## JOYFUL VIEW SUBDIVISION ROADWAY PLAN EL PASO COUNTY, CO

Add text:  
PCD Filing No.:  
SF2231

DESIGNED: MAB DRAWN: AAC CHECKED: RGG DATE: 9/22/2022	RESPEC: RESPEC 121 S. TEJON ST SUITE 1110 COLORADO SPRINGS, CO 80903 PHONE (719) 266-5212	REVISION _____ _____ _____ _____
PROJ NO. W0008.0001		
KEVIN O'NEIL P.O. BOX 1385 COLORADO SPRINGS, CO 80901		
JOYFUL VIEW SUBDIVISION EL PASO COUNTY, CO		
ROADWAY COVER		
DRAWING NUMBER: <div style="font-size: 2em; font-weight: bold; border: 1px solid black; border-radius: 50%; width: 20px; height: 20px; display: flex; align-items: center; justify-content: center; margin: 0 auto;">C</div> SHEET 1

CONSTRUCTION DOCUMENTS
JOYFUL VIEW ROAD

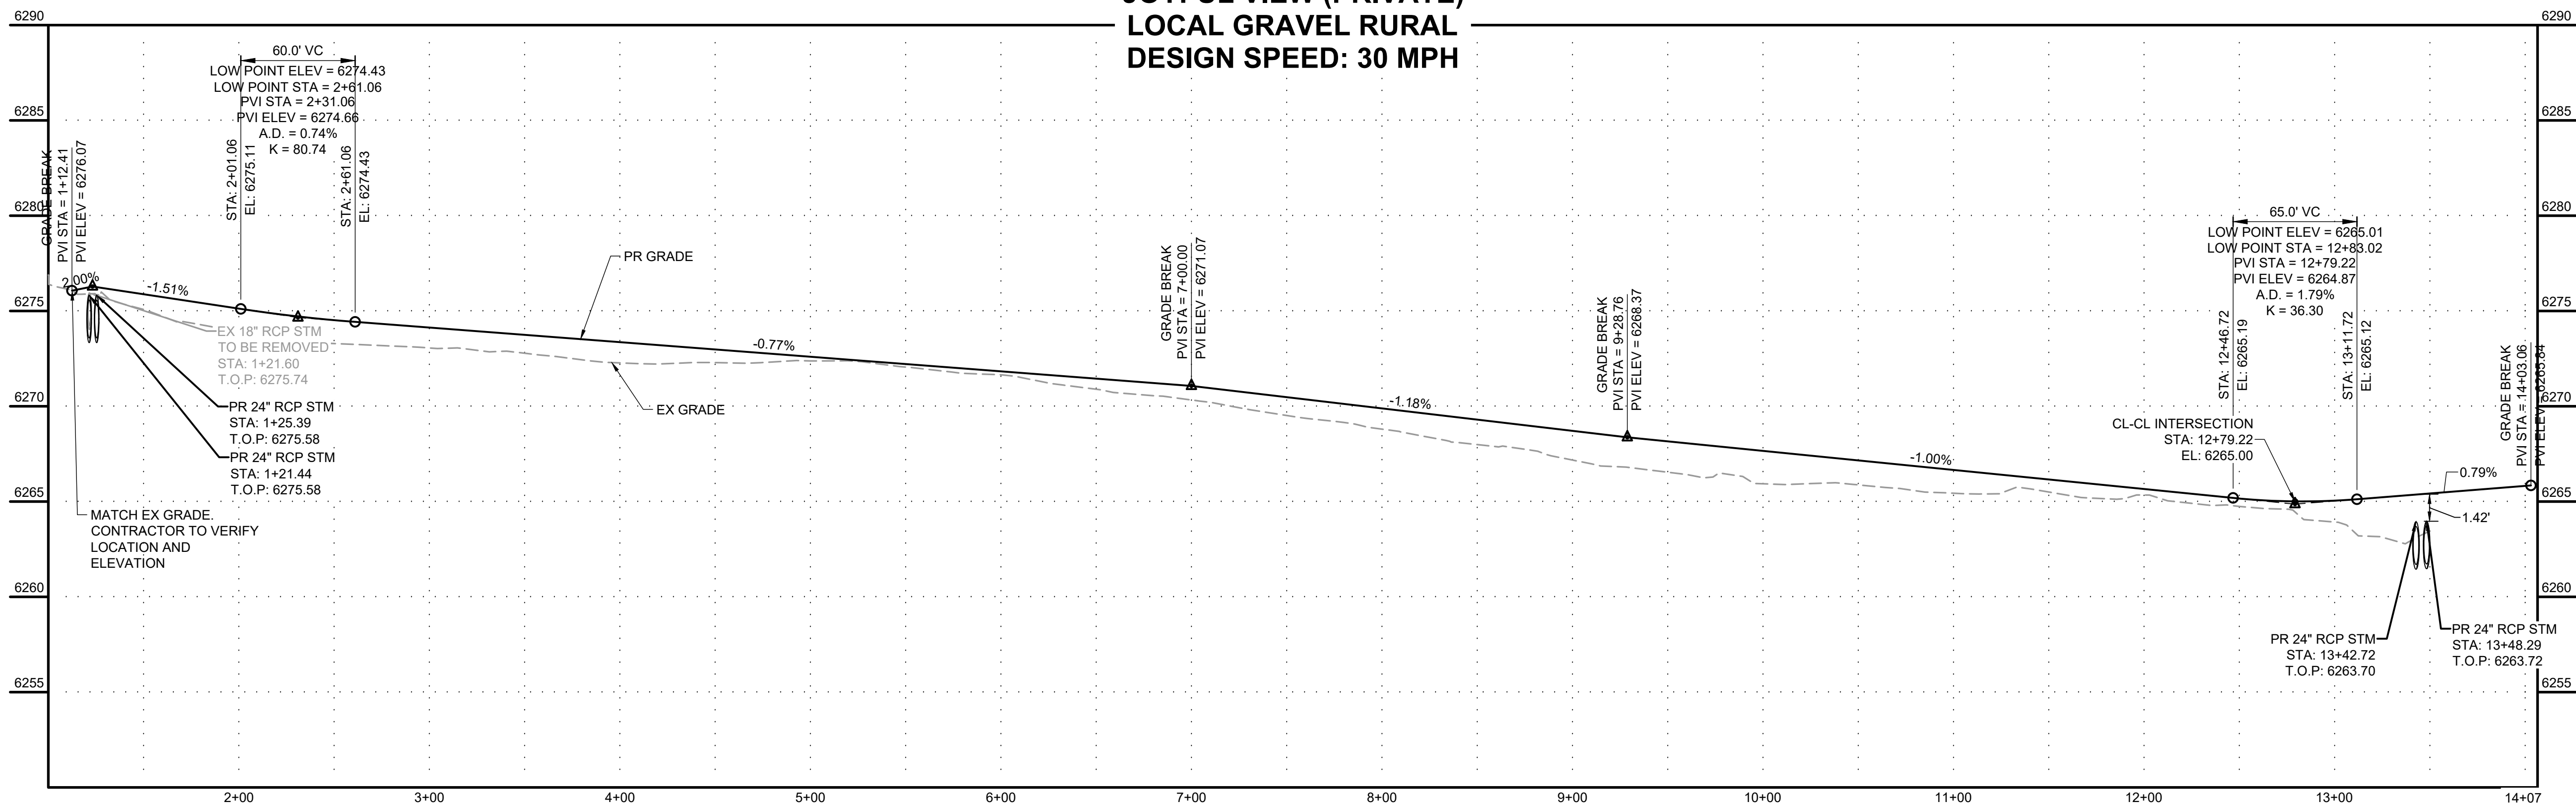
Correct to PVT

Add road classification  
Add design and posted speed.  
Add EPC STD Design detail for the road cross section  
Call out if road is paved or gravel. Road surface type is not consistent across documents (paved vs gravel) please clarify throughout

CONSTRUCTION DOCUMENTS
ELLAS WAY CULDESAC

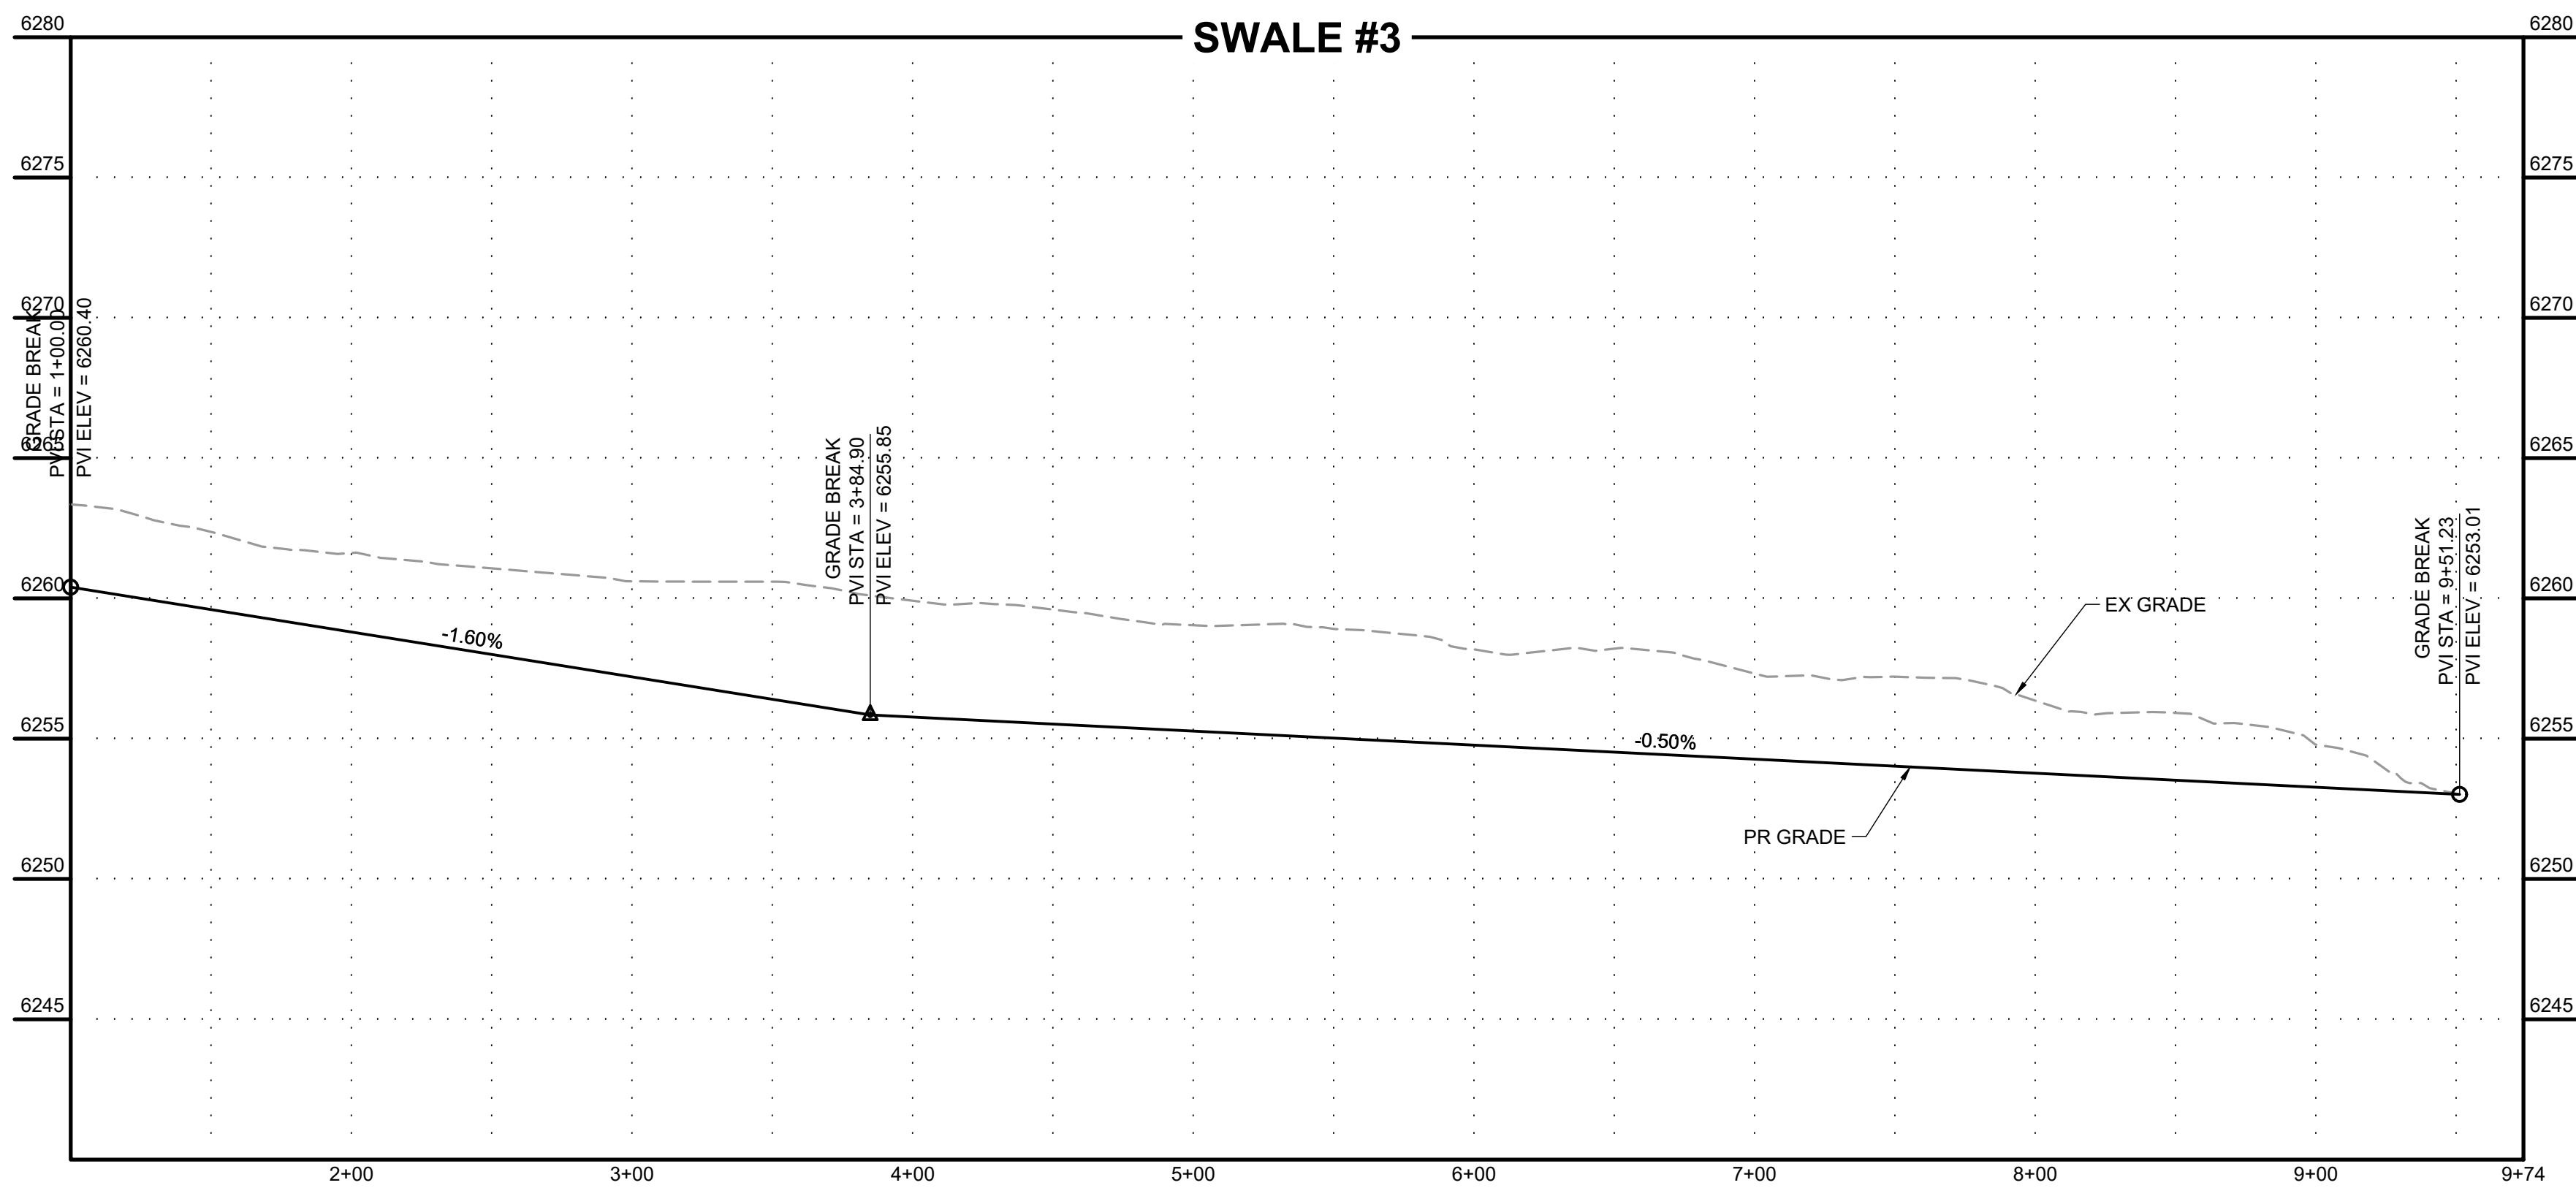
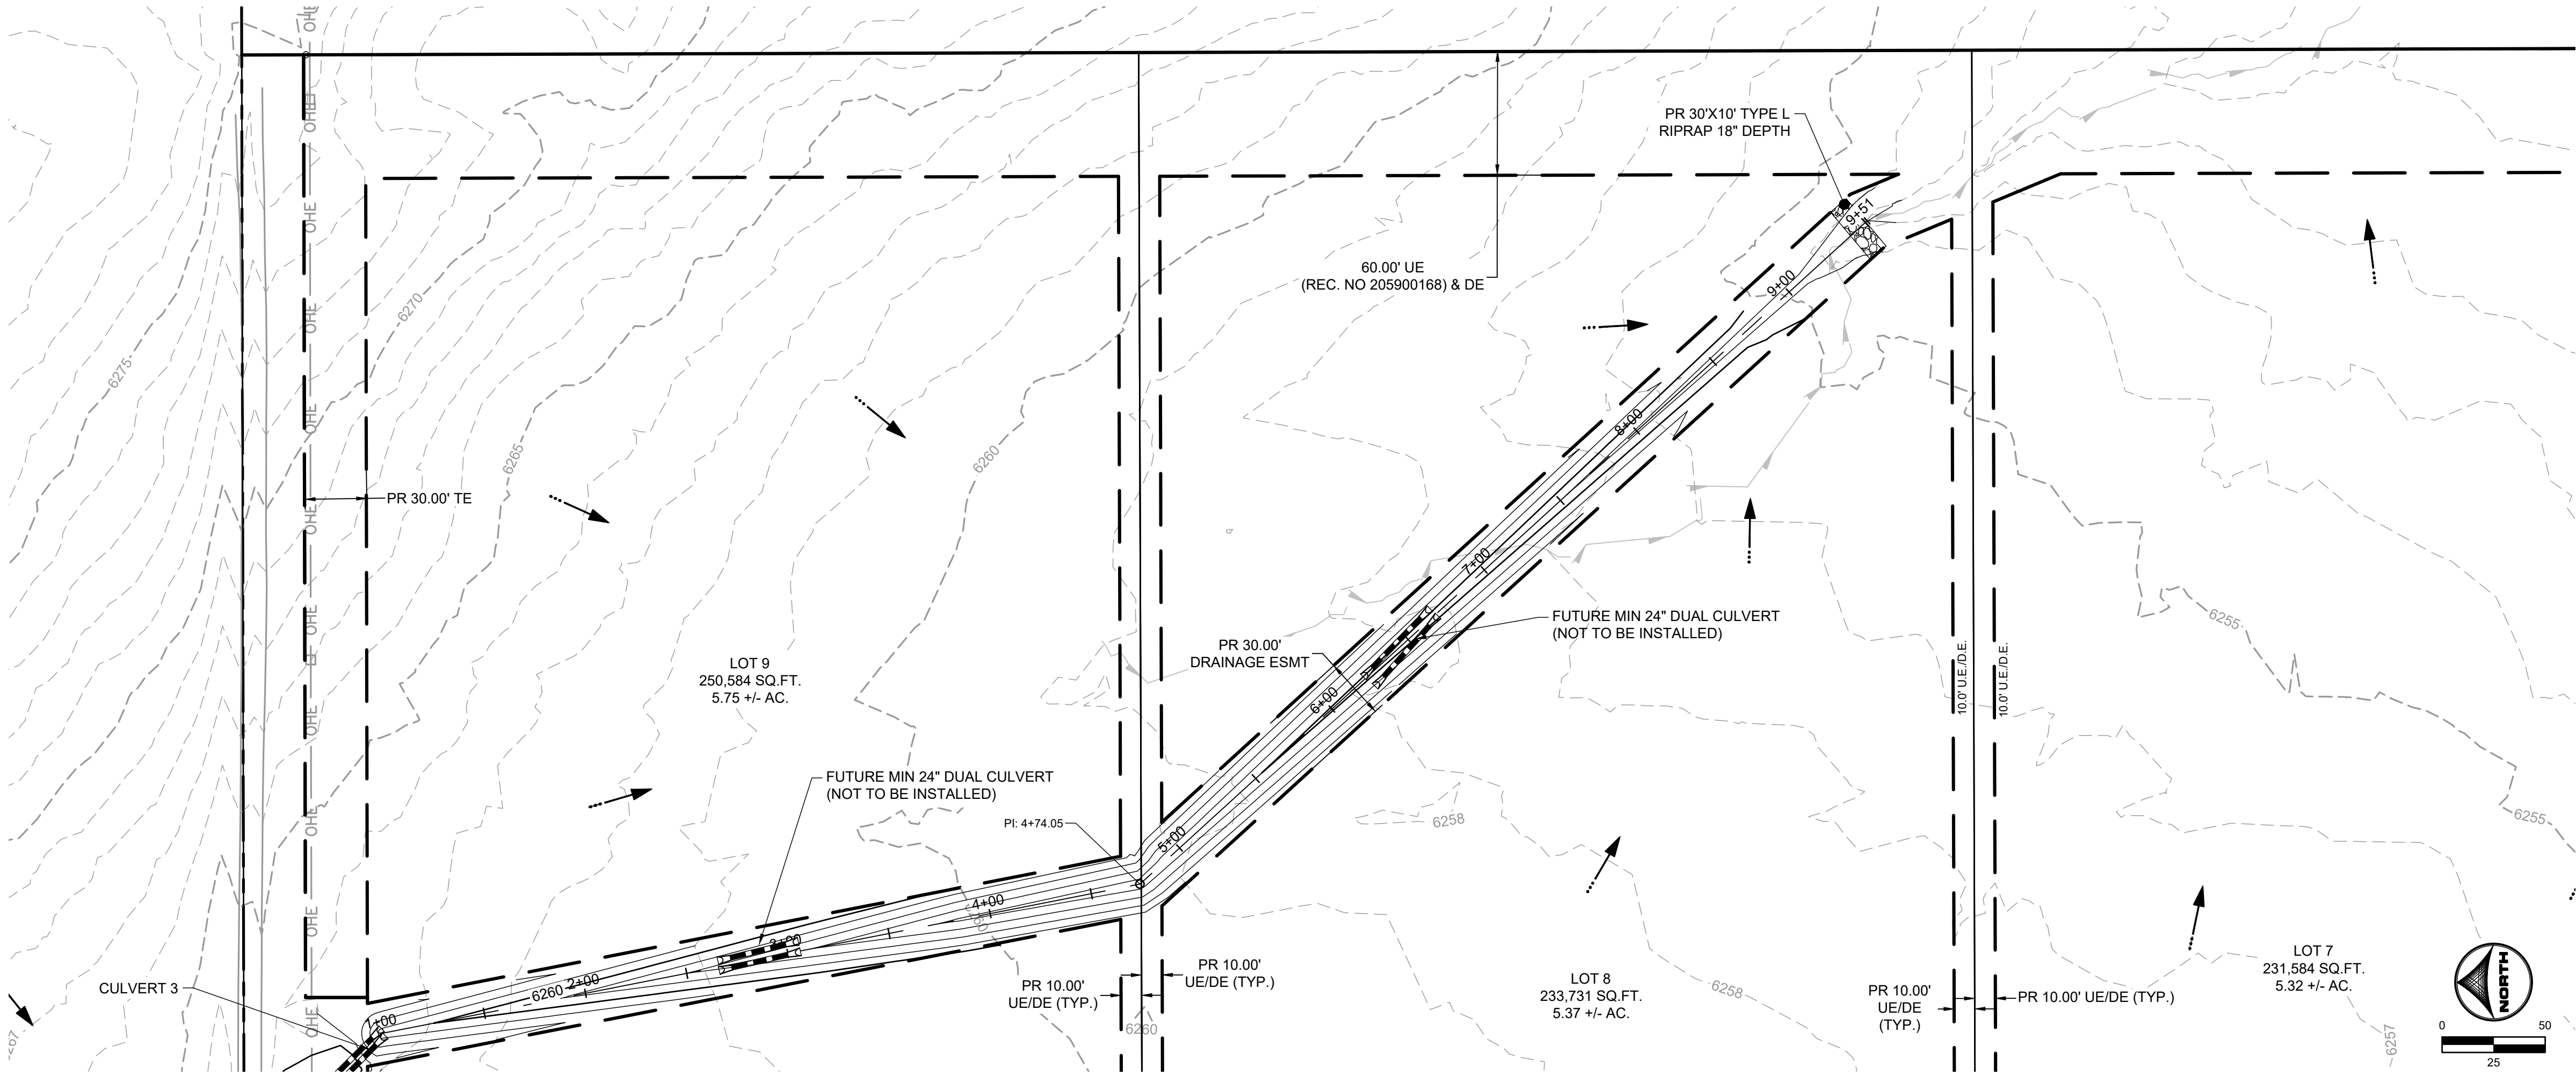
Add all FD required turn around design detail and show on road plan

provide profile at the cul-de-sac

Add the Temp Cul-de-sac for Joyful View design detail and show on road plan
